KITITAS COUNTY

MEMORANDUM

TO: All Staff
FROM: Public Works Plan Review Team
DATE: October 13, 2025
SUBJECT: BL-25-00013 DCYF

RECORD OF SURVEY

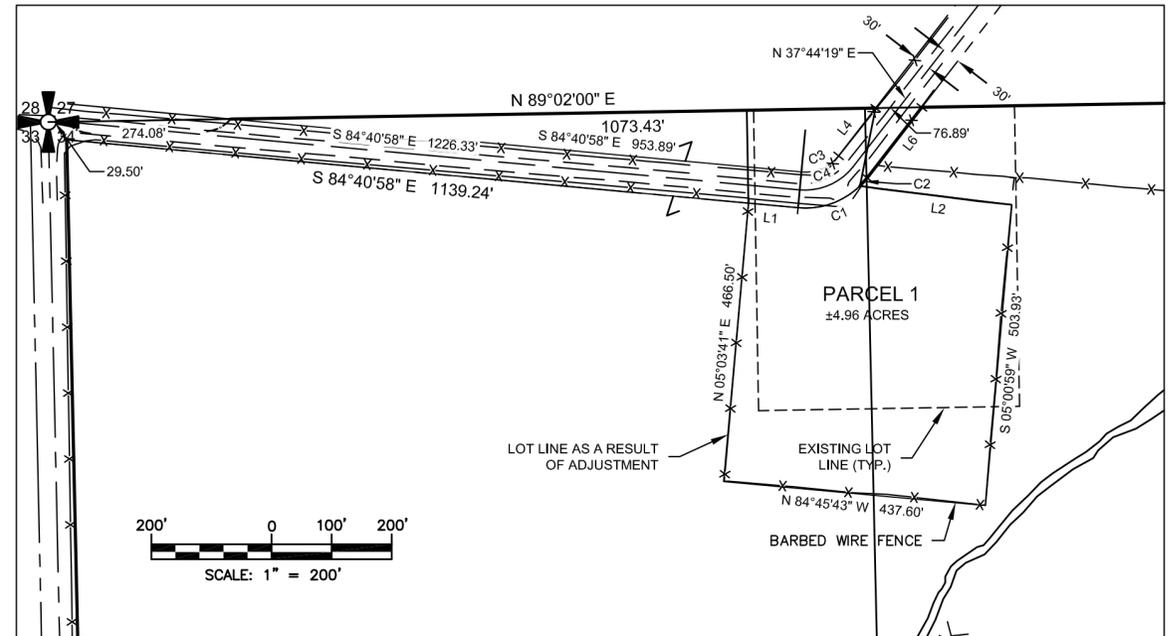
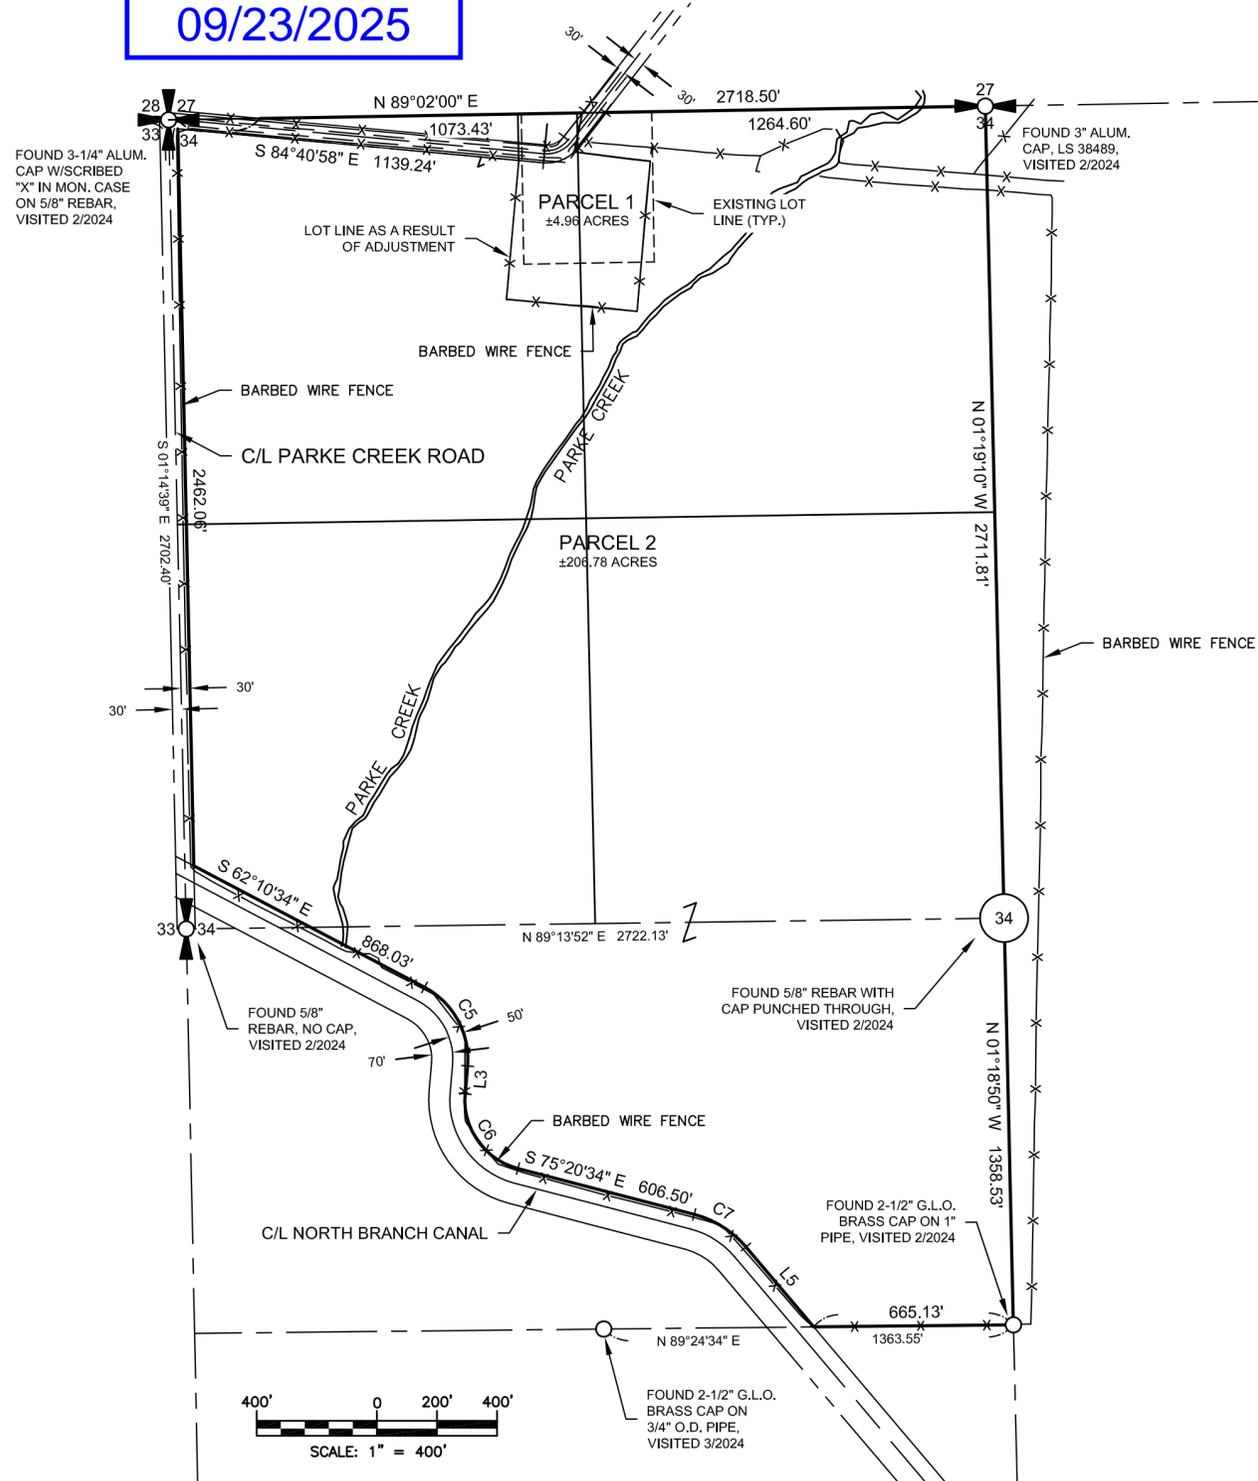
SURVEY	<ol style="list-style-type: none"> 1. Please correct text obscured by crossing linework, including the area of Parcel 2, the distance along the W' most sec line, and the label for Parke Creek. 2. Please identify the 3 solid lines crossing Parke Creek Rd. located north of Parcel 1. 3. Please clarify the distance ties of 29.5 and 274.08 Near the NW corner of Section. 4. Please identify or note the Basis of Bearing. <p>OF NOTE Lot Closures were not provided or reviewed for this project. (JT)</p>
TRANSPORTATION CONCURRENCY	<p>No Comments. (RC)</p>
